*Barnham, Eastergate, Westergate, Chichester,
West Sussex - Realigned A29 & associated highway works*

Road Safety Audit Decision Log Cover Sheet

This report should be read in conjunction with the Stage 1 Safety Audit undertaken by RKS Associates in March 2023.

Crossings Location Plan

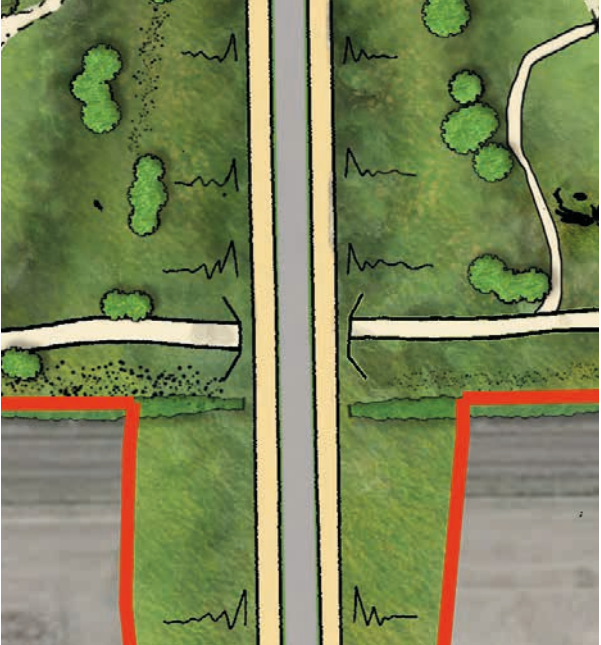
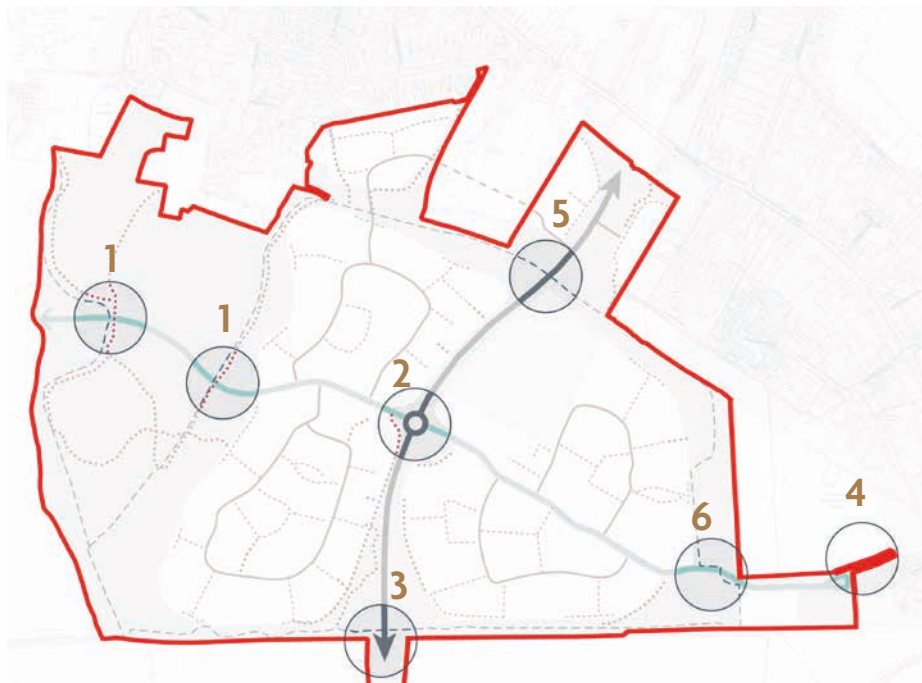
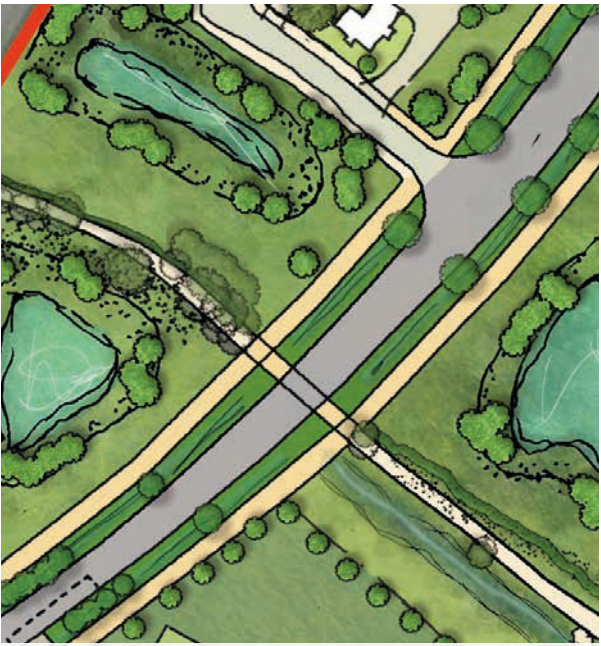
4.3	The proposed pedestrian/cycle crossing facilities across eastern and western arms of roundabout 4 are set back from the entry/exit to the roundabout away from the central splitter islands. The setting back of the crossing facilities may restrict forward visibility to and from the crossing, as a result pedestrians and cyclists using the crossing may be put at unnecessary risk of being struck by vehicles exiting the roundabout. Furthermore the introduction of a zebra crossing on the eastern and western arms is inconsistent with that on the northern and southern arms this may result in non-motorised users inadvertently crossing the carriageway at the uncontrolled crossings without giving way to traffic, this may increase the risk of pedestrians/cyclists being struck by motorists.	The pedestrian/cycle crossing facilities across eastern and western arms of the roundabout should be moved closer to the entry to the roundabout, ensuring that there is sufficient space for a vehicle to wait at the crossing without encroaching onto the circulatory carriageway. If possible the crossing should use the central refuge islands. Further consideration should be given to providing a consistent crossing layout across all arms.	The crossing has been positioned as such to allow for a vehicle to sit off the main A29 corridor whilst waiting at the crossing. Zebra crossings are proposed to maintain the segregated footway/cycleway facilities.	Part-Accept Audit Team Recommendation (about forward visibility) and Part-Accept Design Organisation Response (set-back for vehicles). Design Organisation to reply to the final sentence in the recommendation about consistency of crossings around the roundabout and to also respond to forward visibility concern and to demonstrate that adequate forward visibility is achieved in accordance with DMRB.	24/04/23. Types and locations of crossing on proposed A29 considered in detail in consultation with WSCC. It is not the intention to have signal-controlled crossing on Secondary Roads. To have a continuous Segregated footway /cycleway alongside the A29 the crossing must be controlled. Forward visibility is achieved keeping the crossing within the 20m requirement identified in DMRB

4.4	The proposed pedestrian/cycle crossing facilities across the southern arm of roundabout 4 is set back from the entry/exit to the roundabout. There is concern that setting back of the crossing facilities is away from the crossing desire lines at the roundabout. This may result in pedestrians/cyclists attempting to cross the southern arm at the entry/exit to the roundabout where no crossing facility is provided. This may put pedestrians/cyclists at unnecessary risk of being struck by vehicles entering/exiting the roundabout.	The pedestrian/cycle crossing facilities across southern arm of the roundabout should be moved closer to the entry/exit to the roundabout, where possible making use of central refuge islands. Further consideration should be given to providing a consistent crossing layout across all arms.	This has been relocated closer the roundabout utilising the central refuge island.	<u>12/04/2023.</u> Part-Accept Audit Team Recommendation and Part-Accept Design Organisation Response to it. Design Organisation to respond to the final part of the recommendation, describing what type of crossings are proposed on each arm and why.	24/04/23. Types and locations of crossing on proposed A29 considered in detail in consultation with WSCC.

6.2	The proposed pedestrian/cycle crossing facilities across the eastern and western arms of the roundabout are set back from the entry to the circulatory carriageway. There is concern that setting back of the crossing facilities may restrict forward visibility to and from the crossing, as a result pedestrians and cyclists using the crossing may be put at unnecessary risk of being struck by vehicles exiting the roundabout.	The pedestrian/cycle crossing facilities across the eastern and western arms of the roundabout should be moved closer to the entry/exit to the roundabout, ensuring that there is sufficient space for a vehicle to wait at the crossing without encroaching onto the circulatory carriageway. If possible the crossing should use the central refuge islands.	The crossing has been positioned as such to allow for a vehicle to sit off the main A29 corridor whilst waiting at the crossing. Zebra crossings are proposed to maintain the segregated footway/cycleway facilities.	Part-Accept Audit Team Recommendation (about forward visibility) and Part-Accept Design Organisation Response (set-back for vehicles). Design Organisation to reply to the final sentence in the recommendation about consistency of crossings around the roundabout and to also respond to forward visibility concern and to demonstrate that adequate forward visibility is achieved in accordance with DMRB.	24/04/23. Types and locations of crossing on proposed A29 considered in detail in consultation with WSCC. Forward visibility is achieved keeping the crossing within the 20m requirement identified in DMRB

7.3	The proposed pedestrian/cycle crossing facilities across eastern and western arms of roundabout 11 is set back from the entry/exit to the roundabout away from the central splitter islands. There is concern that setting back of the crossing facilities may restrict forward visibility to and from the crossing, as a result pedestrians and cyclists using the crossing may be put at unnecessary risk of being struck by vehicles exiting the roundabout. Furthermore the introduction of a zebra crossing may result in vehicles queuing back onto the roundabout where the risk of collisions with other road users on the roundabout will be greater.	The pedestrian/cycle crossing facilities across eastern and western arms of the roundabout should be moved closer to the entry to the roundabout, ensuring that there is sufficient space for a vehicle to wait at the crossing without encroaching onto the circulatory carriageway. If possible the crossing should use the central refuge islands.	The crossing has been positioned as such to allow for a vehicle to sit off the main A29 corridor whilst waiting at the crossing. Zebra crossings are proposed to maintain the segregated footway/cycleway facilities.	Part-Accept Audit Team Recommendation (about forward visibility) and Part-Accept Design Organisation Response (set-back for vehicles). Design Organisation to reply to the forward visibility concern and to demonstrate that adequate forward visibility is achieved in accordance with DMRB.	24/04/23. Types and locations of crossing on proposed A29 considered in detail in consultation with WSCC. Forward visibility is achieved keeping the crossing within the 20m requirement identified in DMRB

Junction Visibility Splays based on Table 2.10 from DMRB CD 109. This applies to all junctions on A29 Link Road.

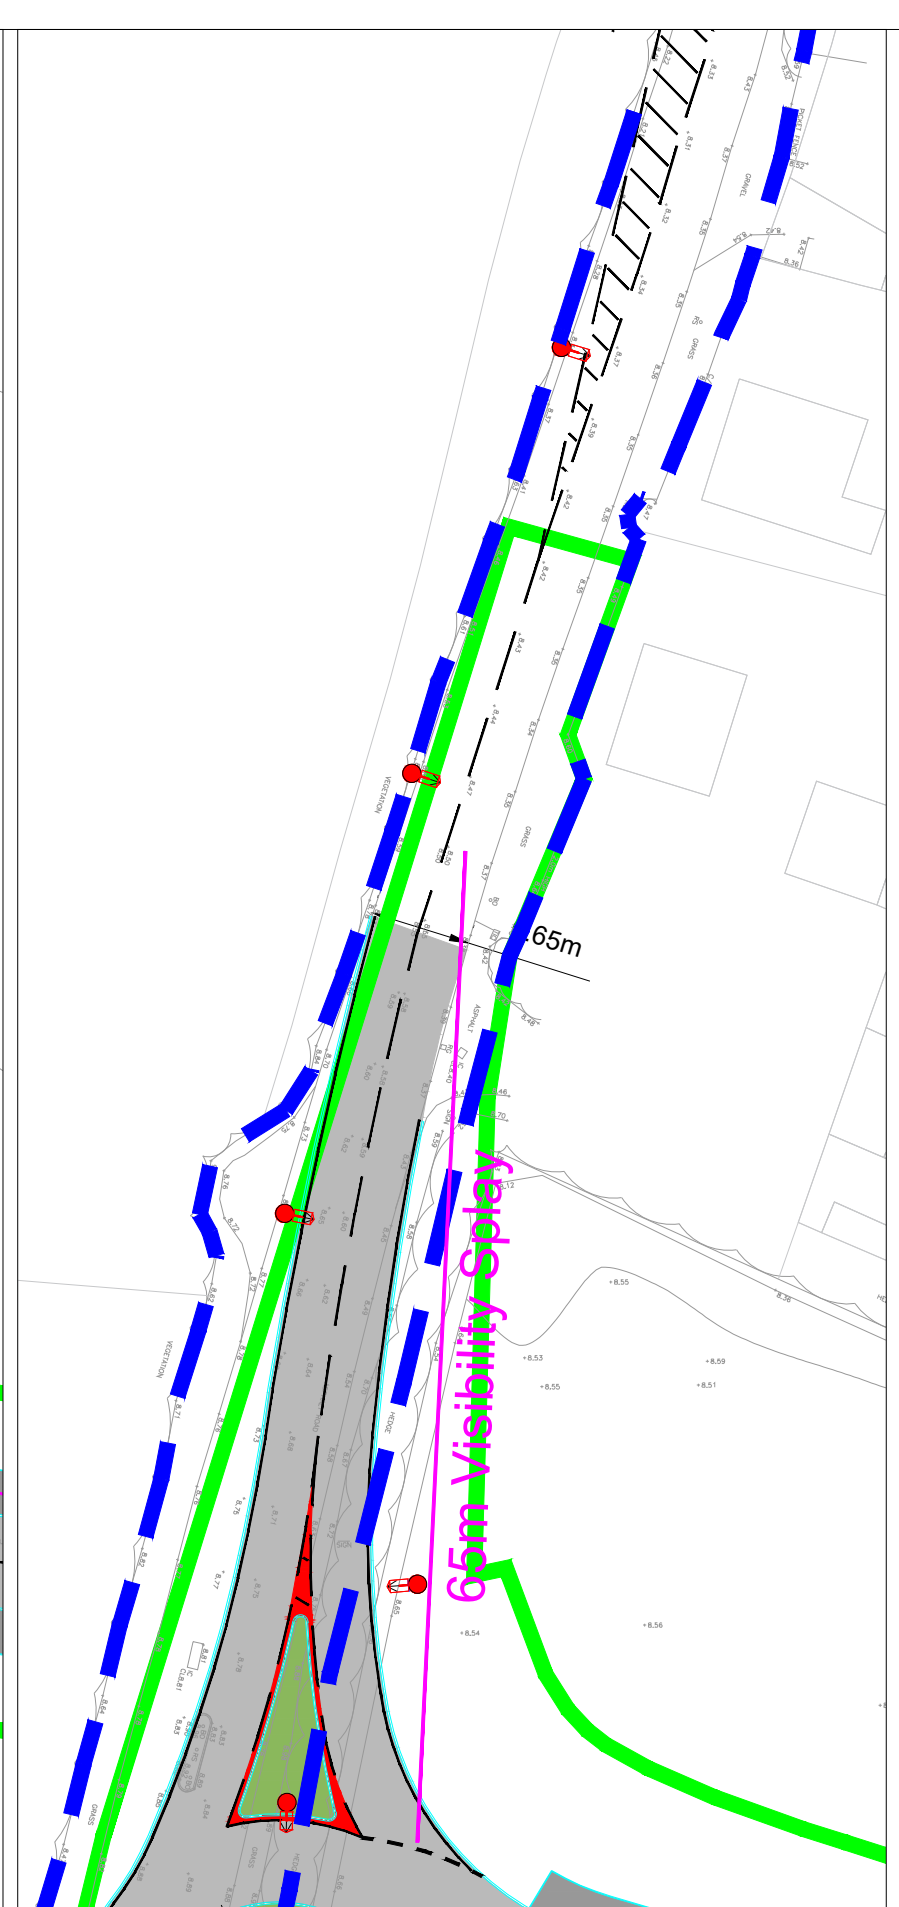
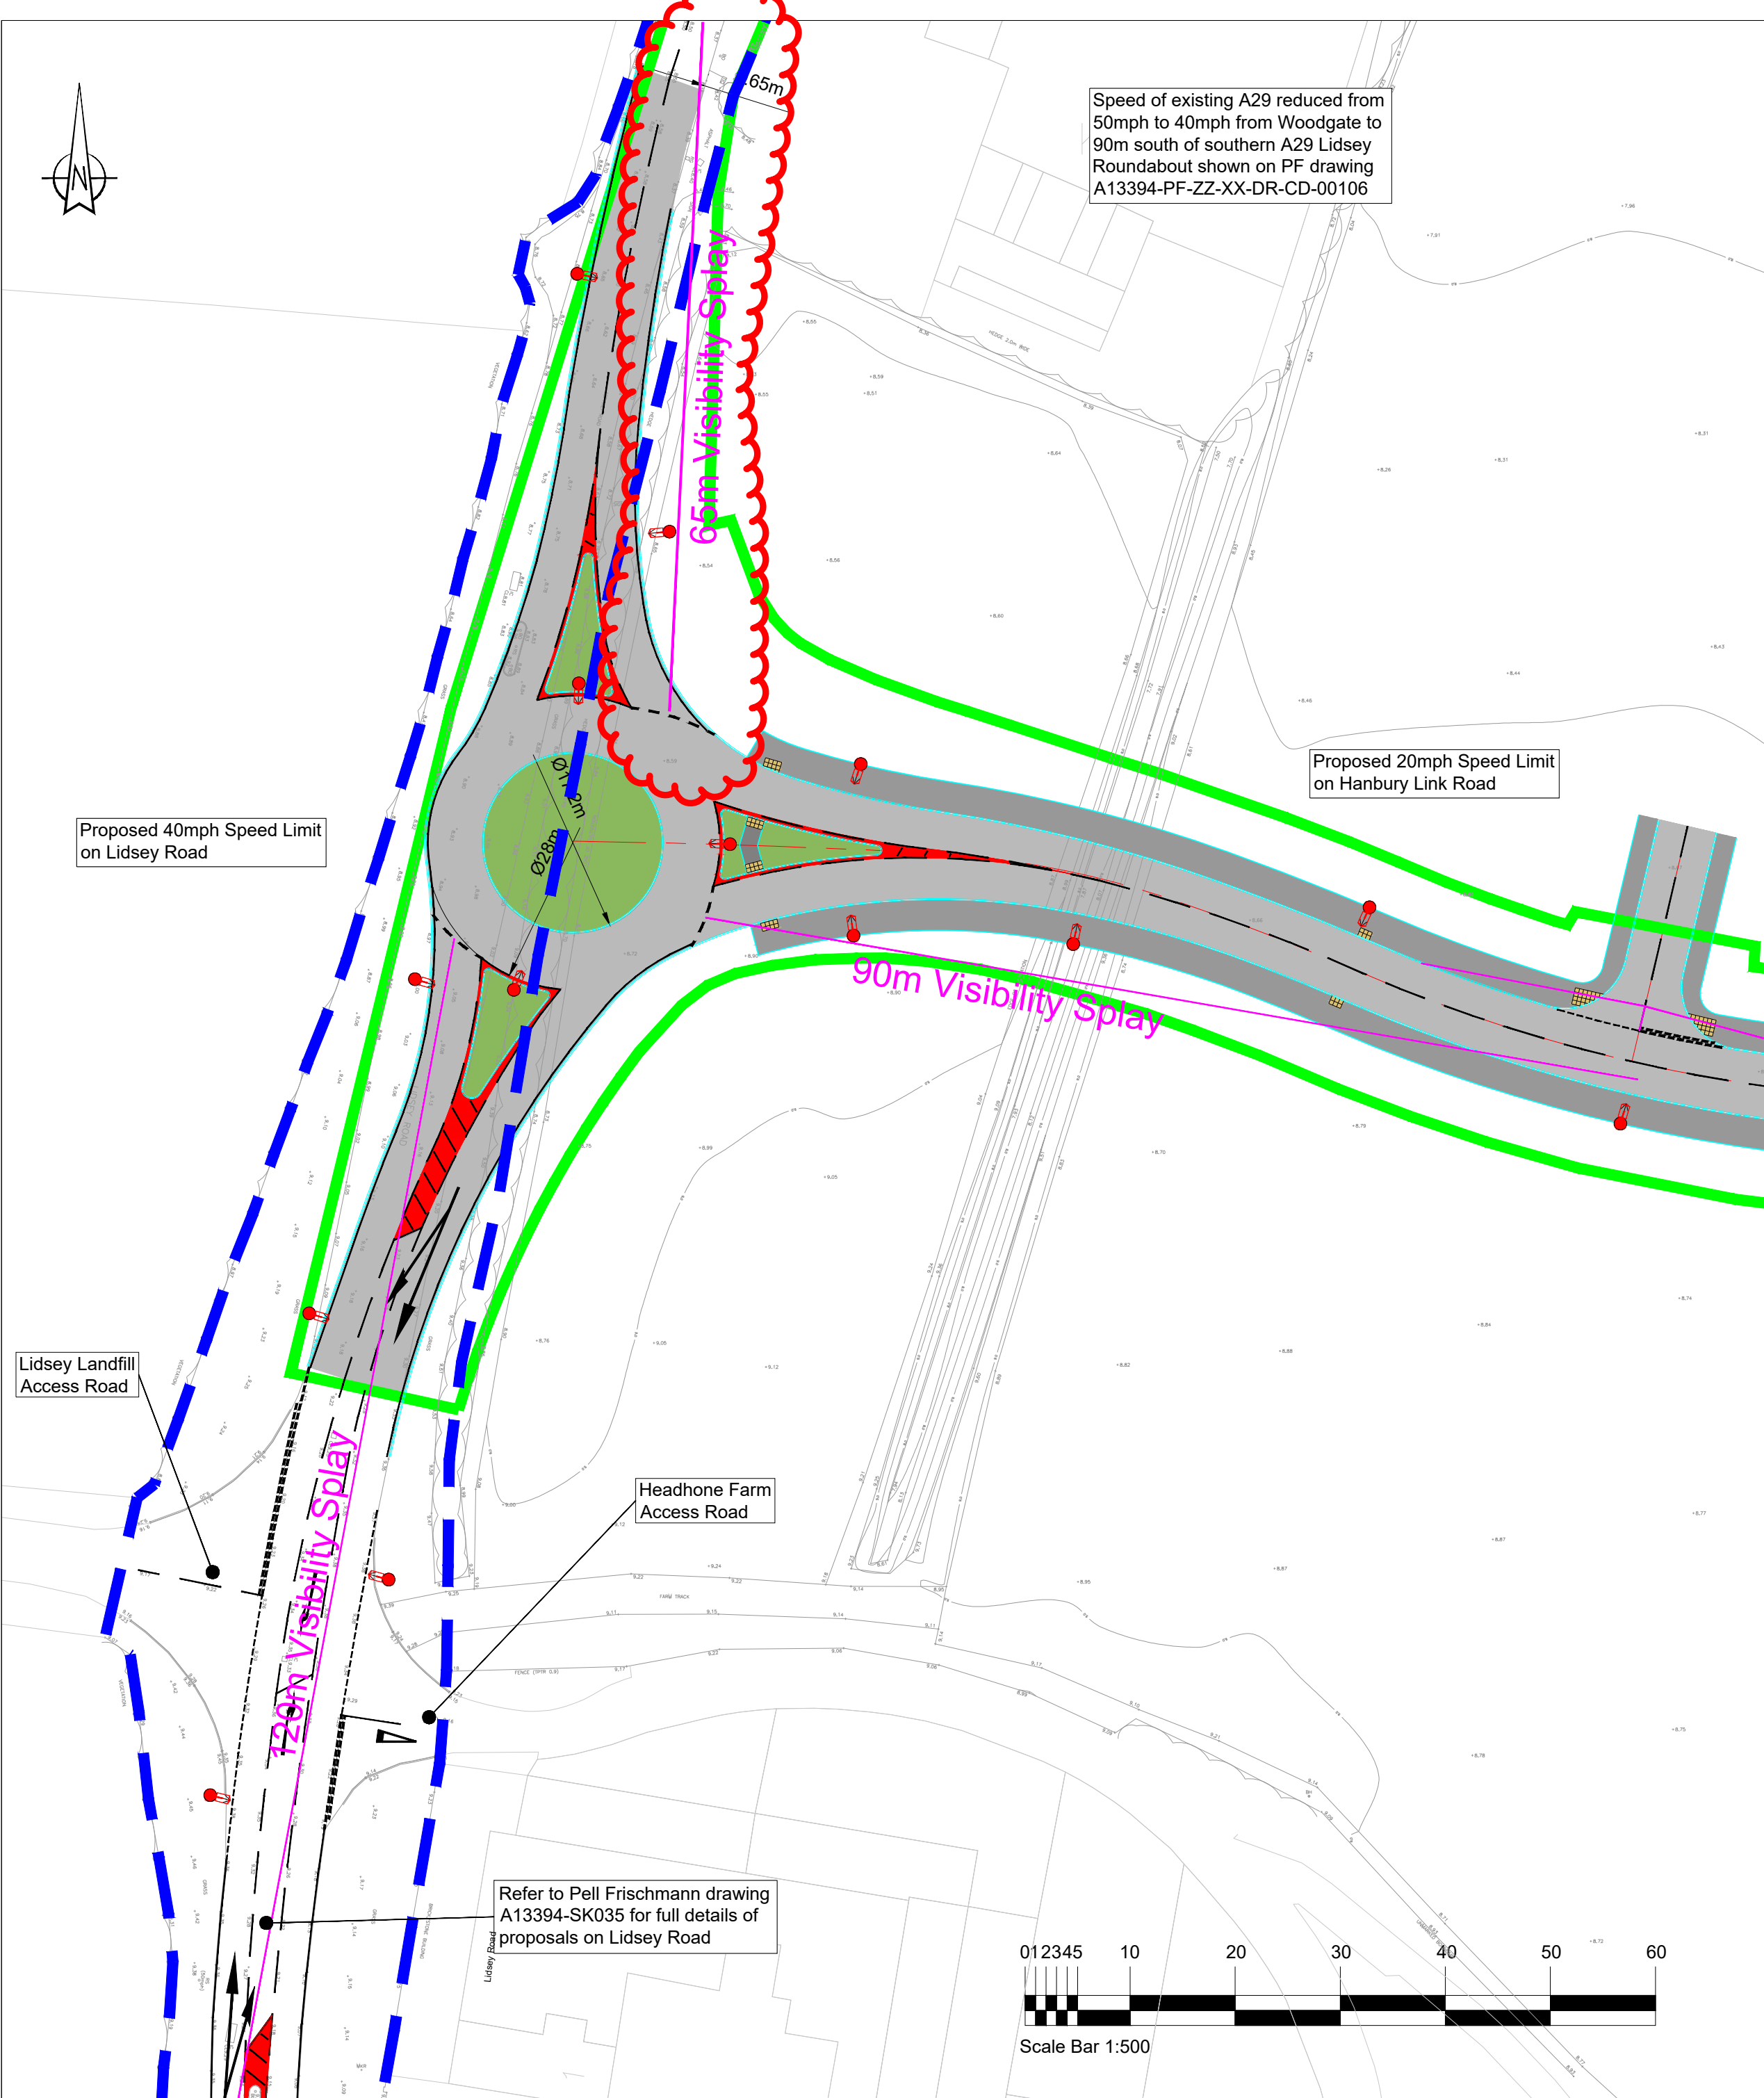
Item No.	RSA Problem	Audit Team Recommendation(s)	Design Organisation Response	Overseeing Organisation Response	Agreed RSA Action
7.4	The scheme drawings indicate that forward visibility along Lidsey Road to roundabout 13 can be achieved. However, there is concern that the forward visibility may be compromised by vegetation/building outside the scope of works. Poor forward visibility to the proposed roundabout may increase the risk of tail end shunts or loss of control collisions between vehicles approaching the roundabout.	Ensure that forward visibility to roundabout 13 is not compromised, if necessary amend the layout.	The position of the roundabout is optimum considering the constraints of the Lidsey Farm access, which will eventually be replaced by an access off the realigned A29 and the ghost island right turn into the Lidsey Caravan Park	Accept Audit Team Recommendation but not Design Organisation Response. Visibility requirements at the junction are due to be considered through a Departure from Standard process which will determine whether visibilities will be suitable, or not. If not, then further measures to support the shown visibilities and/or a re-design of the roundabout might be required.	That appropriate visibilities (including forward visibility) are provided in accordance with DMRB and WSCC requirements. 24/04/23. Achievable visibility splays have been shown on PF drawings, either within Highway or developer ownership. Location of roundabout optimum based upon maintaining access int. Lidsey Farm and right turn Ghost Island into Caravan Park
